In reply please quote: 16/25280
Your reference: SSD 7917 MOD 1

**SSD 7917 MOD 1 SECTION 96(1) MODIFICATION TO THE WAREHOUSE /
DISTRIBUTION & INDUSTRIAL FACILITY, HORSLEY DRIVE BUSINESS PARK,
LOT 3 – 6 BURILDA CLOSE, WETHERILL PARK**

DRAWING NUMBER ISSUE
VI-WSPT-S96-003 B

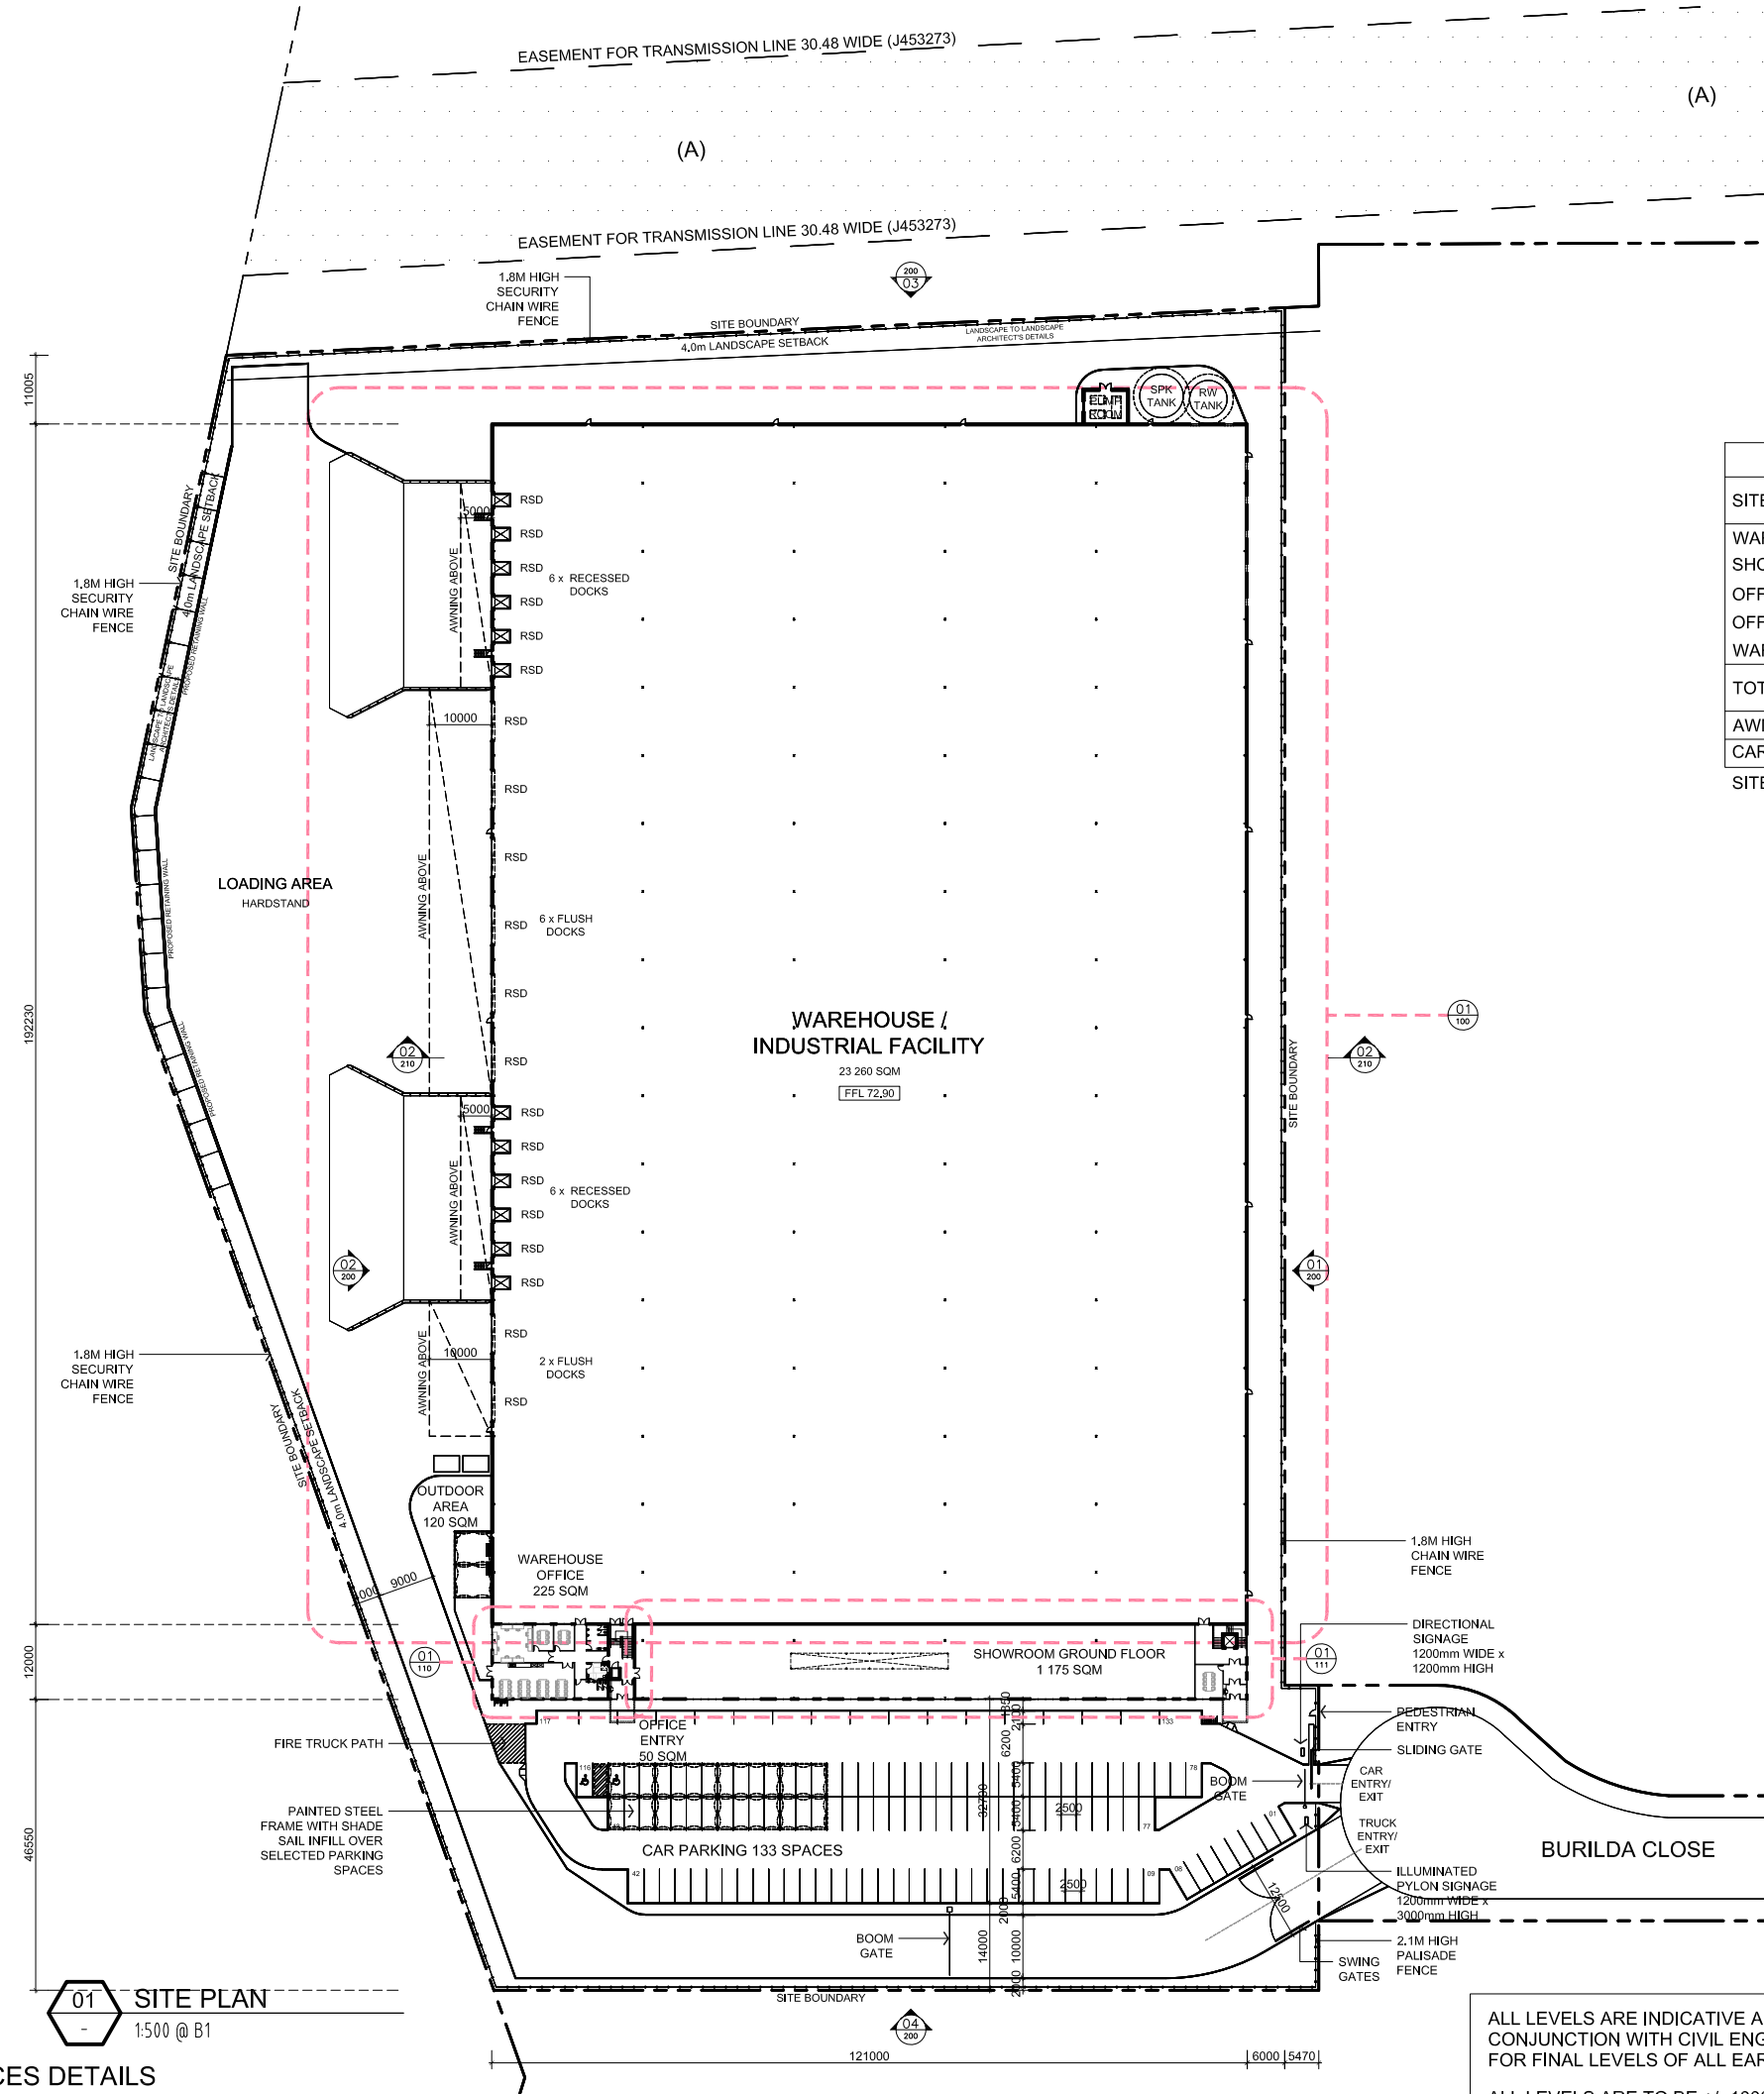
1. Clarification of the hours of operation assessed against the sleep disturbance criteria in the acoustic report;
2. Modification of the acoustic report to show construction hours as:
 - Monday-Friday: 7:00am-6:00pm
 - Saturday: 8:00am-1:00pm
3. Modified site plans showing the waste storage area being covered, bunded and drained to sewer.

Council requests that an amended landscape plan shall be provided which demonstrates landscaping with established large trees is provided on site in particular within the front setback in order to soften the hard stand areas.

V-WSPT-S96-111 B

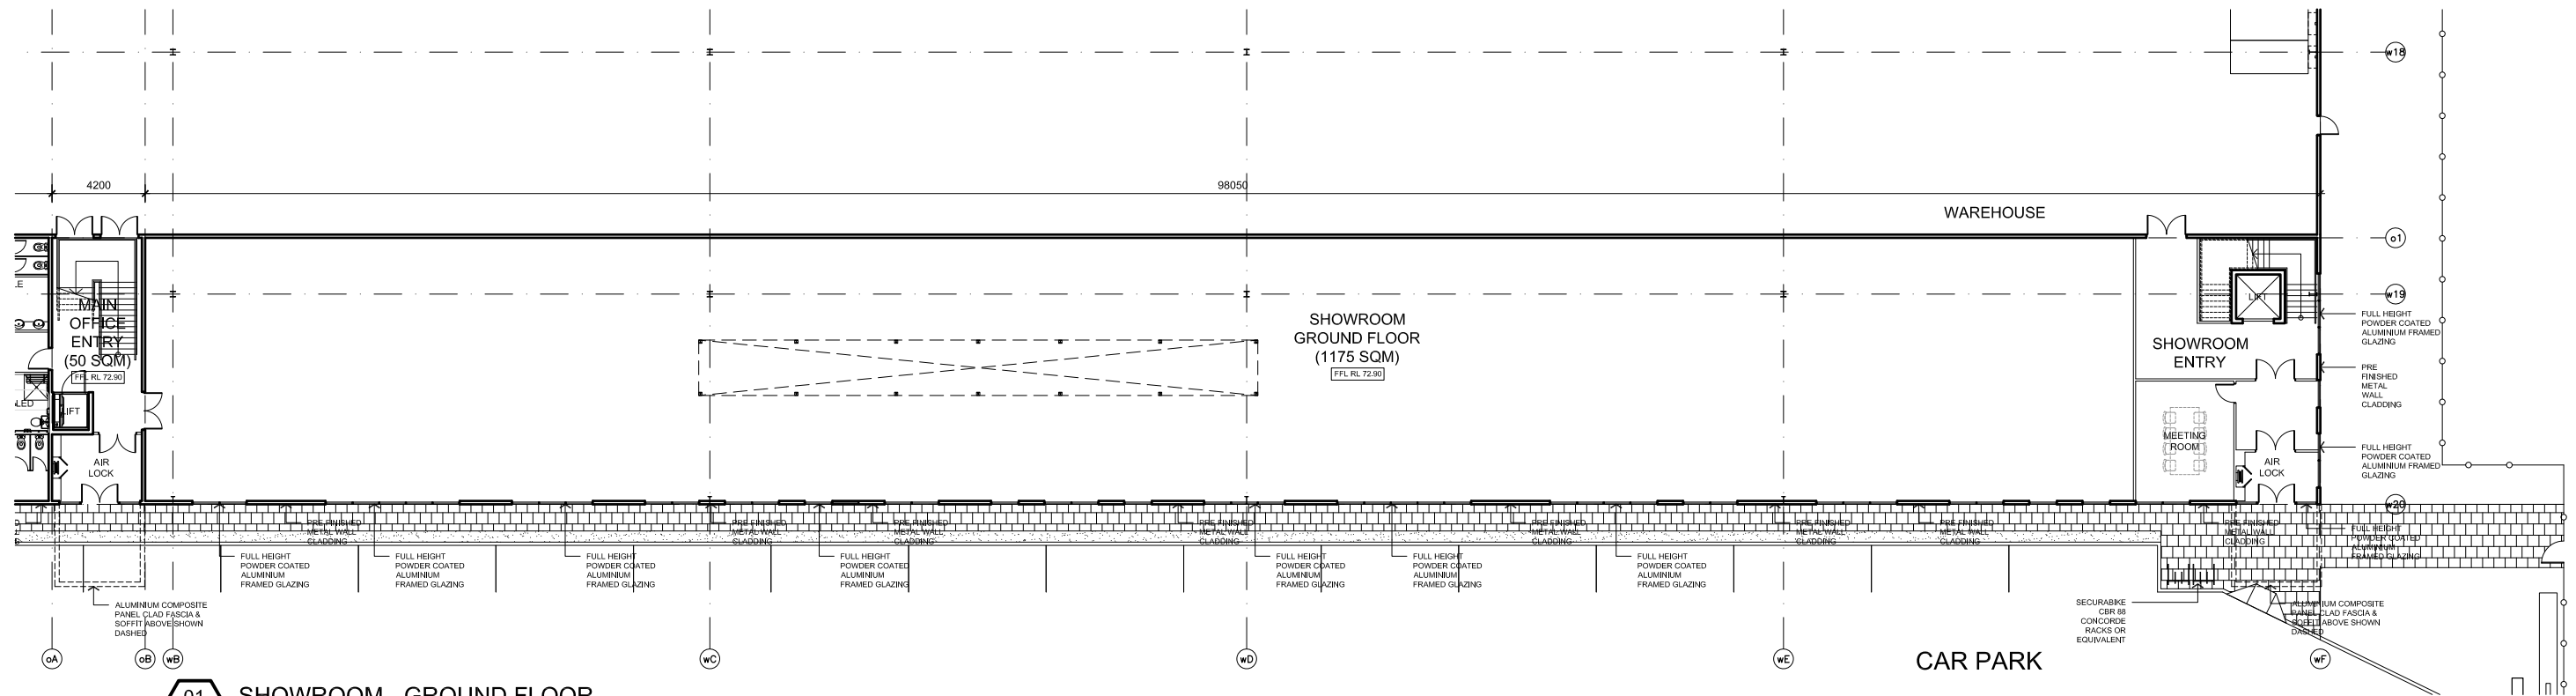
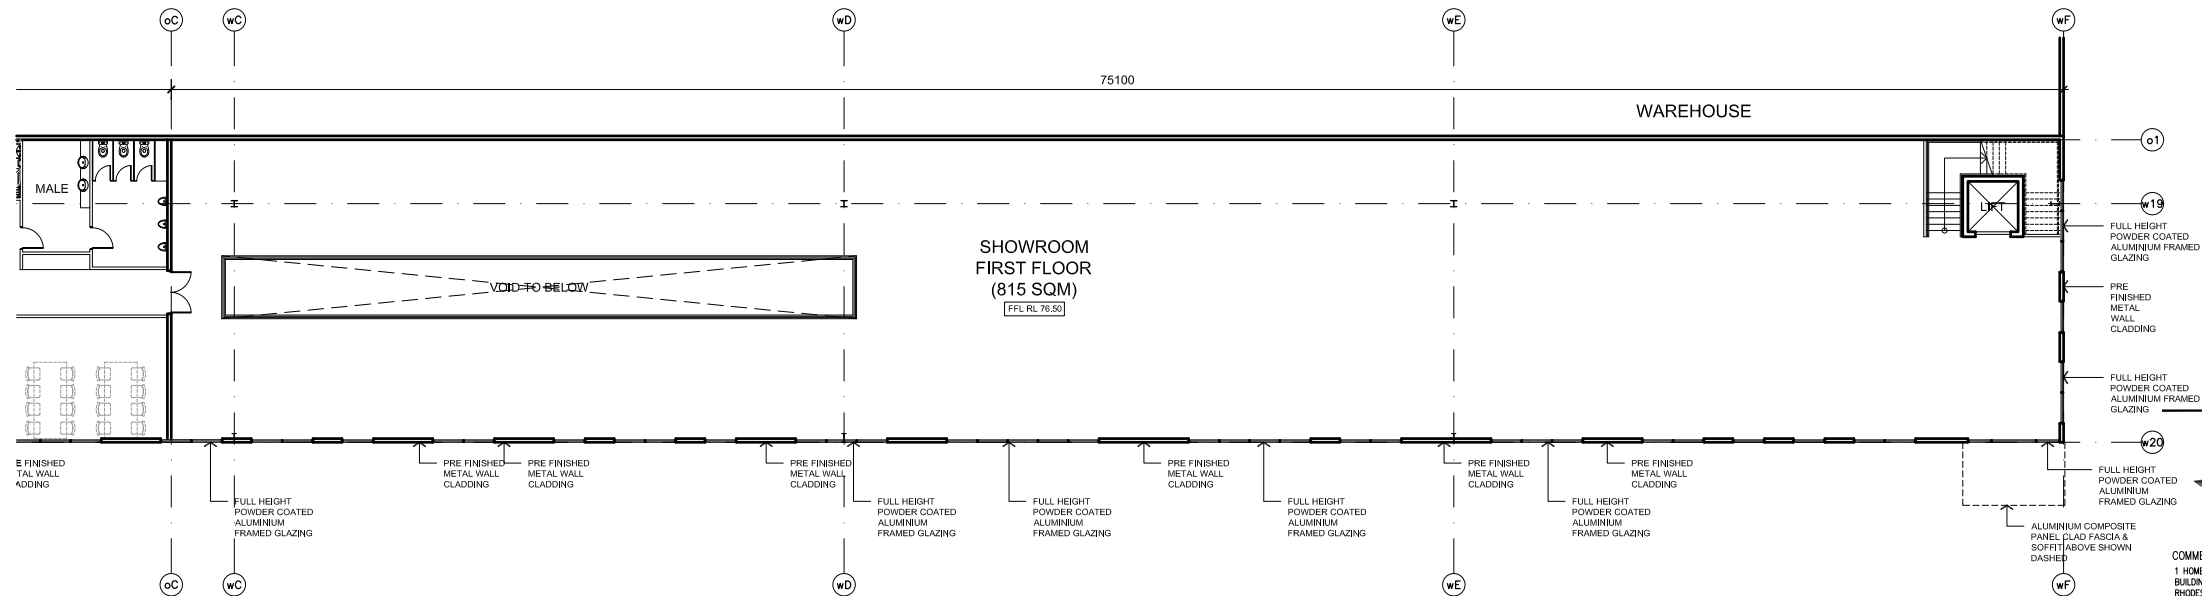
Council notes the showroom component has been introduced to the development. The showroom component is required to be ancillary to the proposal and not the dominant use.
